Re: **5 Dartmouth Square, Dublin 6.**  
Your Ref: **ABP-305895-19**  
Plan Ref: **0354/19**

### APPEAL COMMENTS

**EXPP:** 0354/19 (Section 5 Declaration Application)

**LOCATION:** 5, Dartmouth Square, Dublin 6

Partial Site Plan, Front Garden - PROPOSED

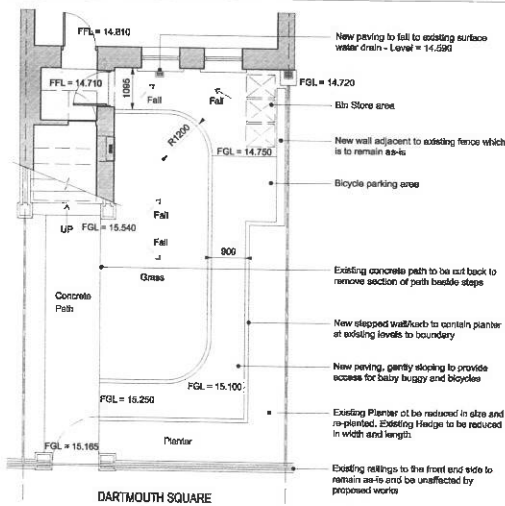
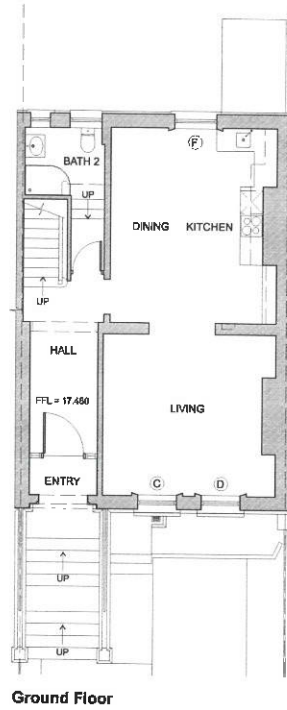
The proposed re-landscaping of the front garden of No.5 Dartmouth Square, as portrayed on the drawings submitted with the application, indicated works over and above the provision of *'a gently sloping path to the lower ground level for baby buggies and bicycles'*. The drawings indicated the construction of wall against the boundary with the house to the north (No.6, also a protected structure). The application as originally submitted did not include sufficient information on the nature and extent of the proposed works, including the provision of the sloping path, to allow the Planning Authority fully determine the impact on the protected structure and whether these could be granted an exemption. To this end, Additional Information was sought from the applicant to allow the proposal to the front garden be fully scrutinised and the impact on the protected structure determined.

The application does not fully detail the proposed work to the front garden to allow full assessment of the impact on the protected structure. A plan of the proposal notes changes in level indicating a drop of c.500mm. A section showing the impact of the sloping path and grass in relation to the protected structure should be provided. The house sits within a terrace of similar houses, all with the same layout of front façade and garden. The introduction of significantly different level to one garden within the terrace will make the garden inconsistent with the surrounding properties. A drawing showing the impact is therefore required to fully assess the proposed work.

The drawing of the proposed front garden notes a wall to be constructed against the boundary with the house to the north. However no further details on this wall are provided including height and materials. The front gardens of the houses along the terrace are divided by metal railings with hedges grown around the railings in some instances, including the boundary in question. Therefore the introduction of a wall abutting the historic railing will not only impact on No.5 Dartmouth Square but also on No.6 Dartmouth Square, which is a protected structure. The construction of the wall will result in the removal of a section of the existing hedge. Details on the height/depth/length of the wall, an elevation drawing showing its height in relation to the front façade of the house and the material to be used in its construction. This information is to include any proposal for a perpendicular wall at its eastern end.

The proposal does not include any details on the material to be used for the new path other than to note that it will be paving. A '*...stepped wall/kerb to contain planter at existing levels...*' is also noted but the material to be used for this is not provided. The applicant is to submit full details on the colour texture and nature of the material to be used for the path in order to assess the impact of this on the protected structure.

Partial Site Plan, Front Garden - PROPOSED

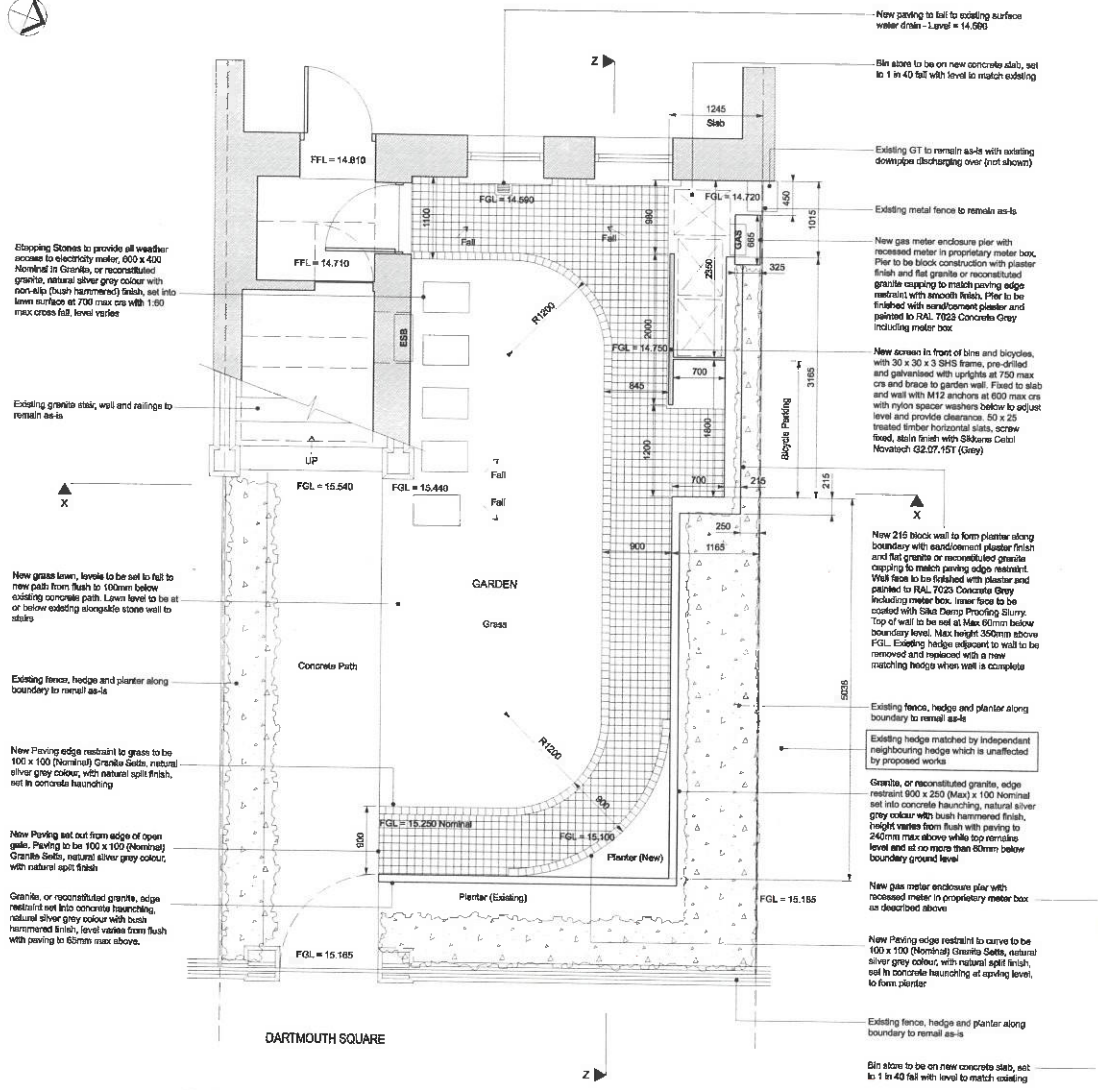
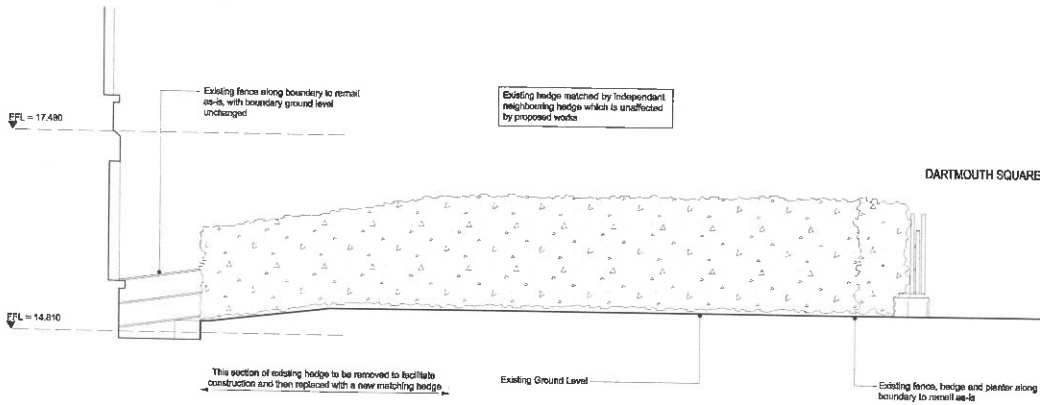
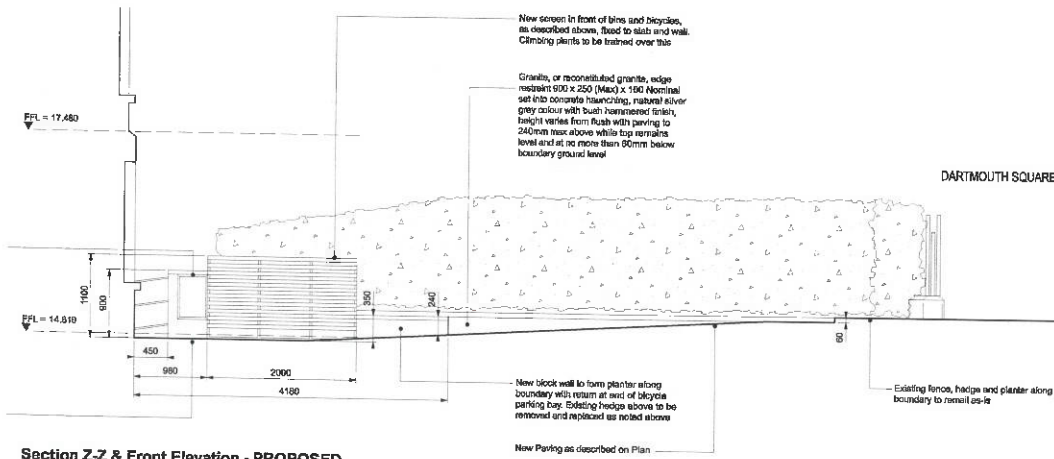
The Additional Information, submitted on the 8<sup>th</sup> October 2019, contained more detailed drawings on the proposals for the front garden which demonstrated that the works would comprise more than originally indicated in the application. The drawings showed the construction of a timber screen 1100mm in height to form a bin store with a screened area for bicycles alongside this. Notwithstanding the impact of this structure within the curtilage of the protected structure and on its boundary with No.6 Dartmouth Square, under Schedule 2, Part 1 of the Planning and Development Regulations, a Class 3 structure cannot be considered exempted development if *'...erected or placed forward of the front wall of the house...'*. A Class 3 structure is considered to be a *'...tent, awning, shade or other object, greenhouse, garage, store, shed or other similar structure'*. The proposed walls and screen to the front of this structure will form a bin store (it is named a *'Bin store'* on the Proposed Section Z-Z & Front Elevation drawing) and, together with the bicycle area to the immediate east, are deemed to be a structure under Class 3 Schedule 2 Part 1 of the Planning and Development Regulations. Its location forward of the front wall of the house infers this proposed work is development and therefore requires planning permission.

5. **Re-landscaping the front garden, without making any changes or works to the existing railings; to provide a gently sloping path to the lower ground level for baby buggies and bicycles.** Insufficient details of the proposed landscaping works has been provided. The proposed work will result in the loss of some soft landscaping to the front site, which will impact on the setting of the protected structure. The boundary railings to the front site and the gate will not be impacted by the works.

- The Additional Information submitted on behalf of the applicant provides details on the wall to be constructed. The plans/sections/elevations presented indicate that the applicants propose to provide a timber screen 1100mm in height and 700mm in front of the proposed concrete wall along the boundary with No.6. In addition, a gas meter enclosure is proposed directly in front of the boundary railing to the garden of No.6. This was not apparent on the original submission and clearly demonstrates that it is effectively proposed to construct a structure within the front garden. Under Schedule 2, Part 1 of the Planning and Development Regulations, a Class 3 structure cannot be considered exempted development if '*...erected or placed forward of the front wall of the house...*'. A Class 3 structure is considered to be a '*...tent, awning, shade or other object, greenhouse, garage, store, shed or other similar structure*'. The proposed walls and screen to the front of this structure will form a bin store (it is named a '*Bin store*' on the Proposed Section Z-Z & Front Elevation drawing) and, together with the bicycle area to the immediate east, are deemed to be a structure under Class 3 Schedule 2 Part 1 of the Planning and Development Regulations. Its location forward of the front wall of the house implies infers this proposed work is development and therefore requires planning permission.

The proposed landscaping works to the front of No.5 Dartmouth Square will materially affect the character of the protected structure and are therefore considered development. The Department of Culture, Heritage and the Gaeltacht's *Architectural Heritage Protection Guidelines for Planning Authorities* states that '*Proposals for new development within the curtilage of a protected structure should be carefully scrutinised by the planning authority, as inappropriate development will be detrimental to the character of the structure.*' (2011, 199) The proposed walls and screen will be adjacent to the front elevation of the house and clearly visible from within the garden. These form part of substantial landscaping works that will significantly alter the front garden. The Additional Information submitted notes the provision of a new gas meter enclosure adjacent to the bin store and '*stepping stones*' set within the lawn along the route of the concrete path to be removed; these had not previously been indicated. The new paved area will be of granite setts and together with the stepping-stones (also granite) and the raised height of planters along the boundary to accommodate the sloped pathway, the collective effect of the proposed works will see a significant loss of soft landscaping within the front garden. The Guidelines note that '*...regardless of its size, a garden can make an important contribution to the character and setting of a protected structure...*' (2011, 197). The introduction of the sloped paved area, which will introduce a different level within this garden to that of its

Note: The landscaping works proposed include the provision of a bin store/bicycle storage area, gas meter enclosure, sloping pathway and increased hard landscaping as shown on Drawings 1808-S5-2.1.0 and 1808-S5-2.1.1. The cumulative effect of the proposed interventions to the front garden of the protected structure would materially affect its character and cannot be considered exempted development.
